Baiada Integrated Poultry Processing Facility (SSD-9394)
Request for Additional Information

Attachment 1 Request for Further Information

[PHA – A] SEPP 33 Preliminary Risk Screening & Hazard Analysis, Proposed Baiada Oakburn Poultry Processing Facility, 1154 Gunnedah Road, Westdale NSW 2340, SSD-9394 (document number 6.10.19171-R02, version -v1.2, dated 18 September 2020, prepared by SLR Consulting); and

[PHA – B] Risk Assessment, 1154 Gunnedah Road, Westdale, NSW 2340 (document number 370593-LoteRA-BaiadaPoultryPlant-RevB, revision B, dated 17 September 2020, prepared by Lote Consulting).

Figure 5-1 – Overpressure Contours from a Vapour Cloud Explosion

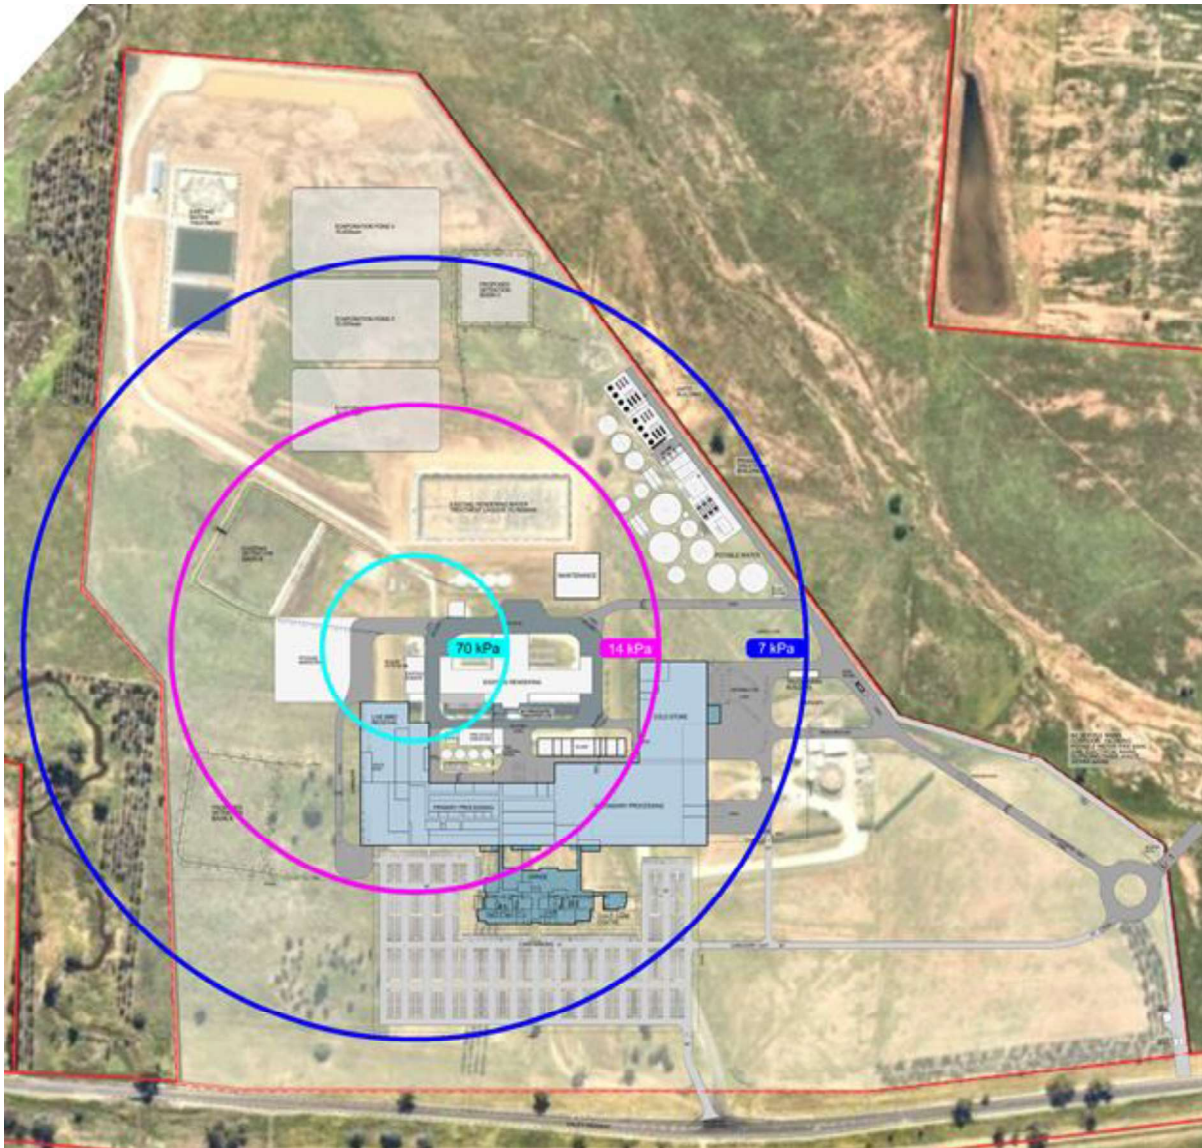
Noting from PHA – B Figure 5-1 that the 14 kPa covers a significant portion of the development, please verify:

- a. that accident propagation risks which may involve anhydrous ammonia, oxygen gas or LOX have been appropriately addressed as part of the PHA
- b. a cumulative risk assessment has been performed as the sum of the risks associated with anhydrous ammonia, LNG, oxygen gas and LOX.
